City of Albuquerque

June 11, 2002

RE: Anderson Warehouse Grading and Drainage Plan (J14-D142)
Engineer's Stamp Dated May 16, 2002

GRADING AND DRAINAGE

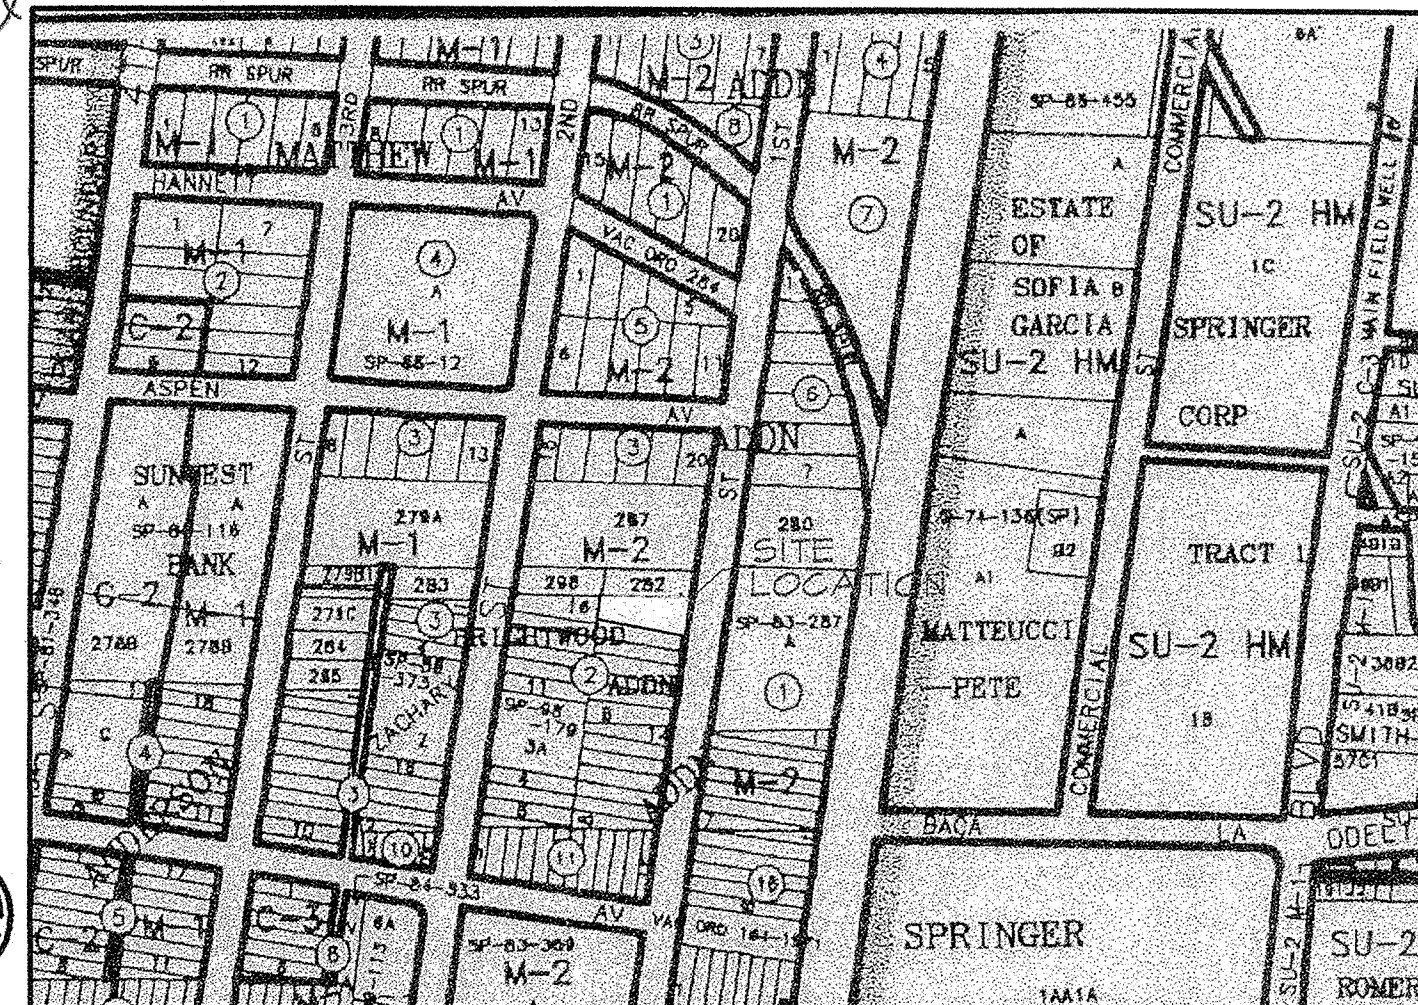
- Please address if there are any off-site flows. If there are none, please state so in your commentary.
- First Street is located within a 100-year floodplain (AO-1'). The finish floor needs to be elevated one-foot above the floodplain elevation.
- With the one-foot water block, how is the runoff from the site going to discharge to the street? As long as the building is elevated the water block can be removed.
